WEST SUSSEX COUNTY COUNCIL CONSULTATION

TO:	Arun District Council FAO: Zac Denton
FROM:	WSCC - Highways Authority
DATE:	30 January 2020
LOCATION:	141 Wick Street Littlehampton BN17 7JY
SUBJECT:	LU/297/19/PL 1 No. new dwelling (resubmission following LU/84/19/PL). Amended plans received.
DATE OF SITE VISIT:	n/a
RECOMMENDATION:	Advice
S106 CONTRIBUTION TOTAL:	n/a

SITE PLAN
PROPOSED
1:100 @A3

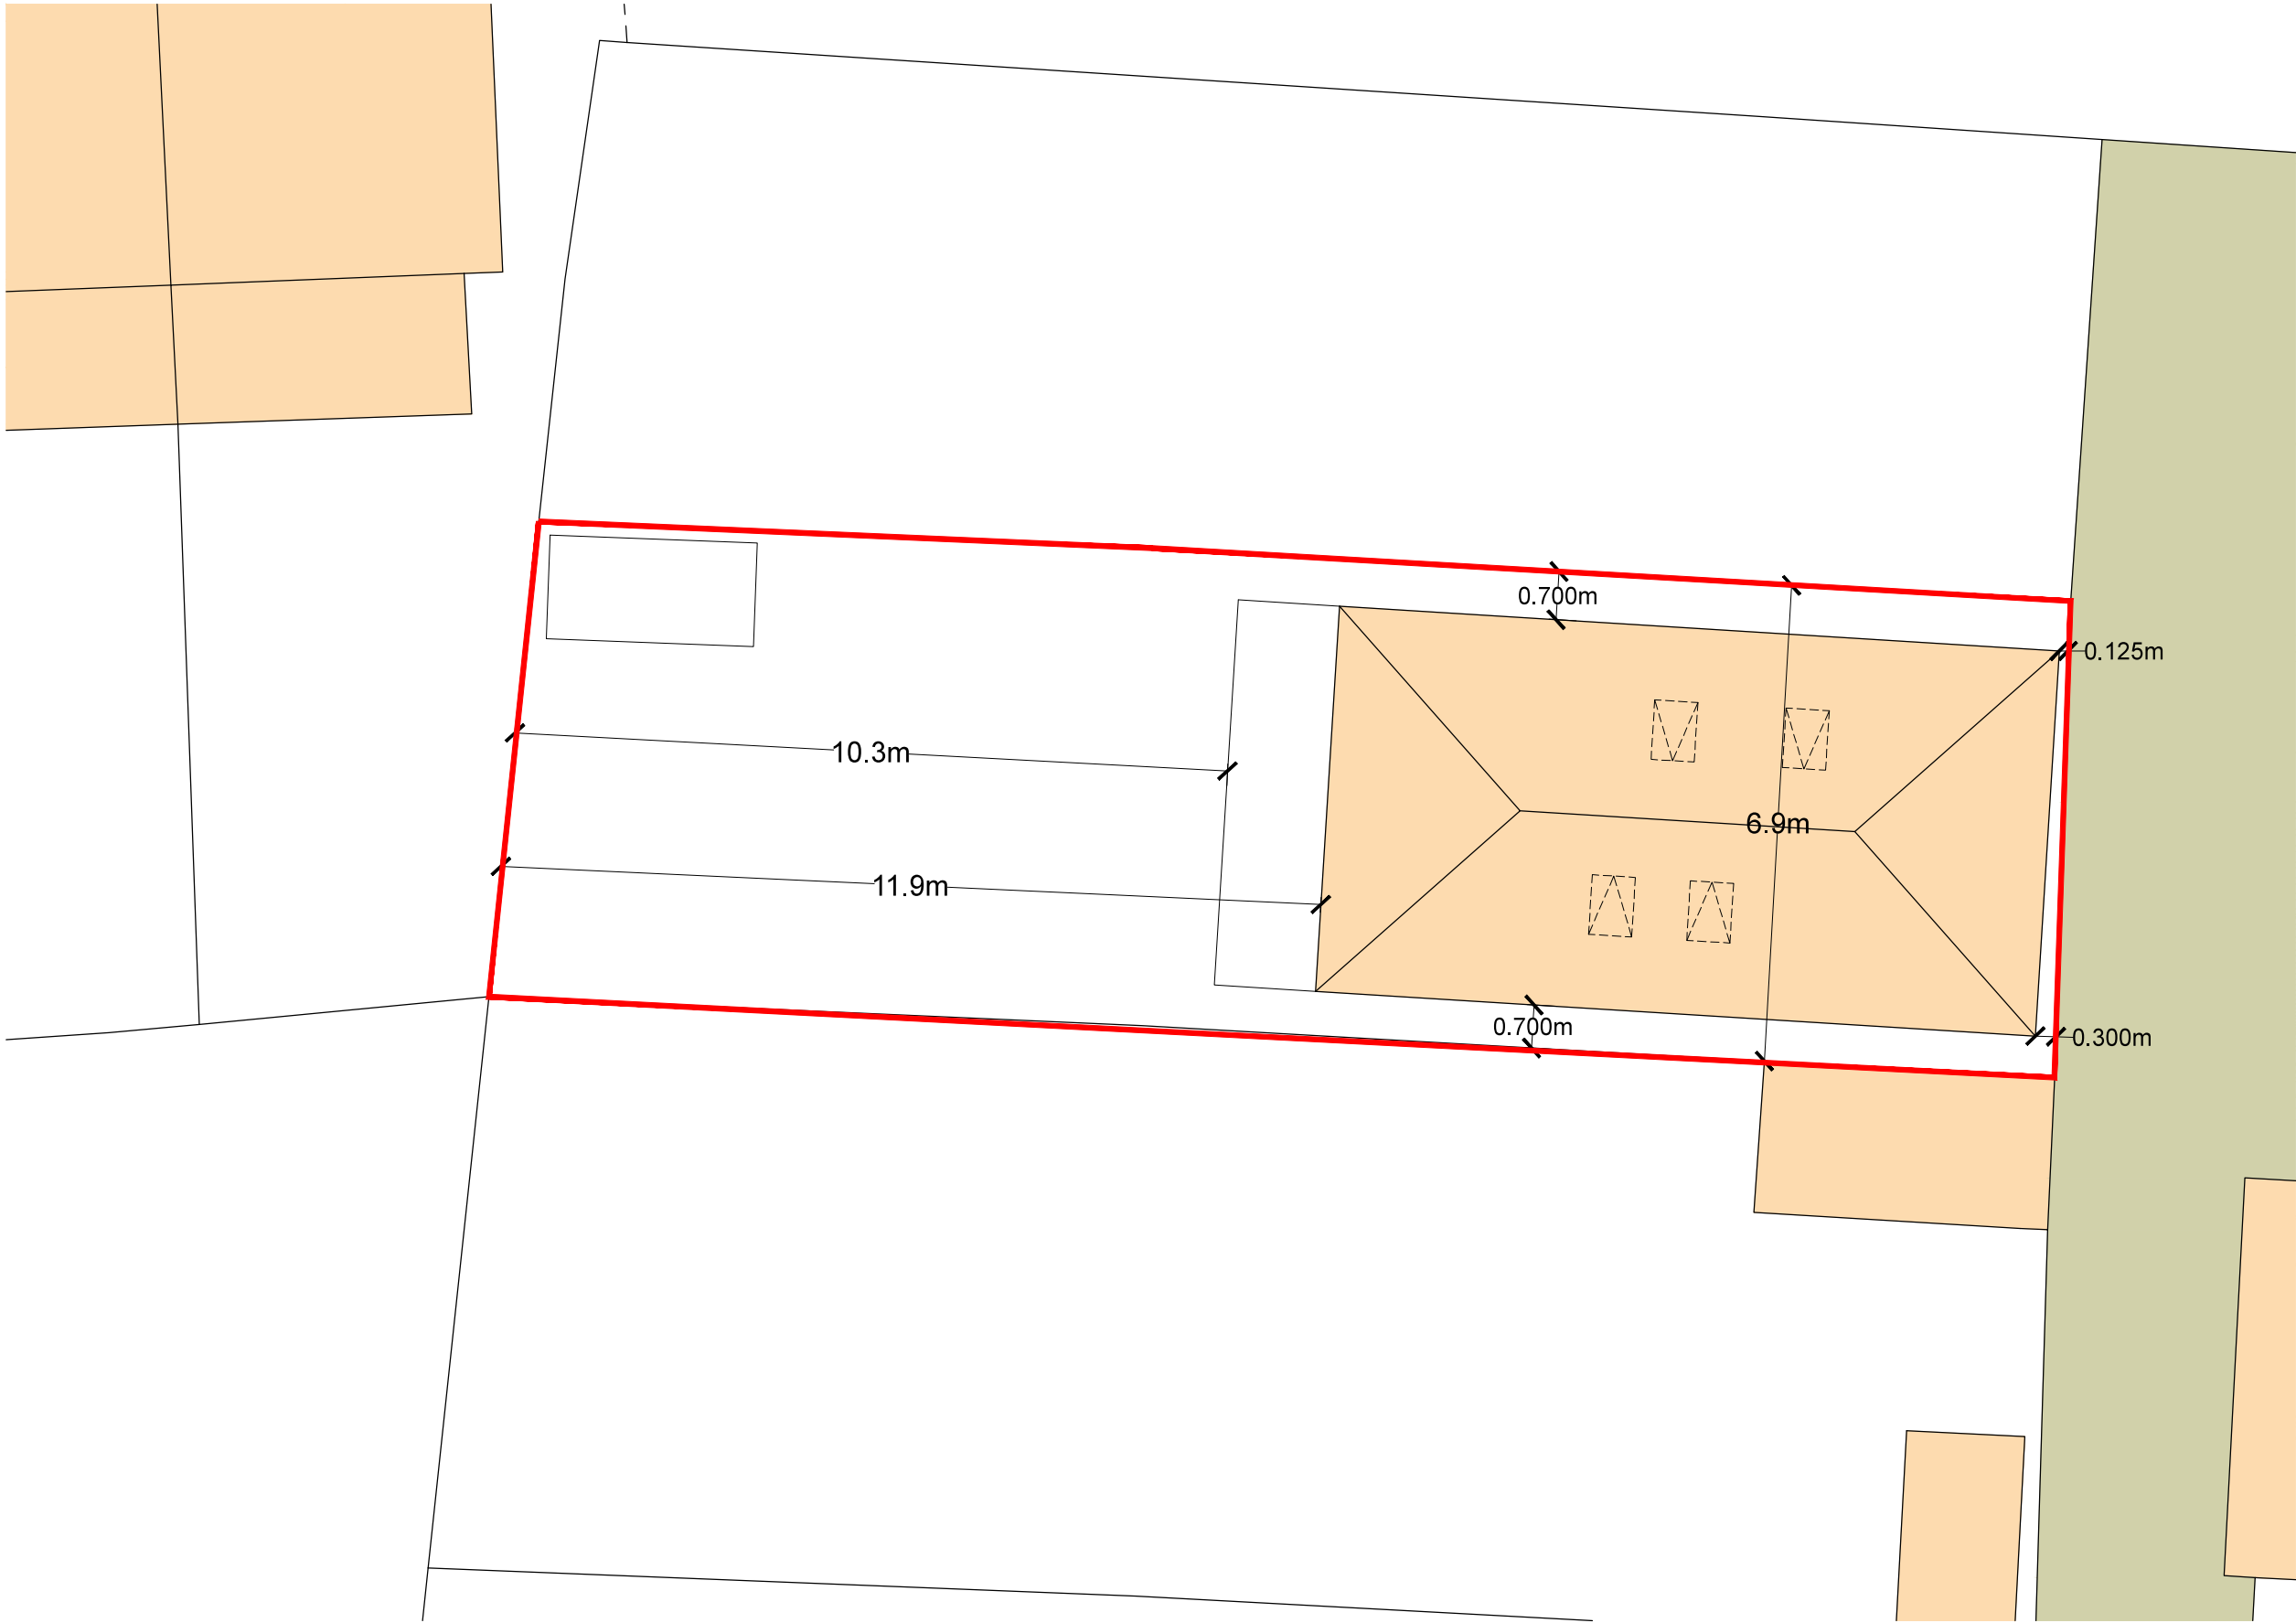
The applicant has removed the proposed garage which did not conform to WSCC and Manual for Streets (MfS) guidance on garage dimensions. Instead the applicant proposes a parking area measuring 6.9 x 4.8 metres this would be large enough to accommodate a two car parking provision. Under Arun Car Parking Guidance (adopted January 2020), 2 car parking spaces should be provided for the proposal. The LHA are satisfied with such amendments and conclude with the following.

No part of the development shall be first occupied until the car parking has been constructed in accordance with the approved site plan. These spaces shall thereafter be retained at all times for their designated purpose.
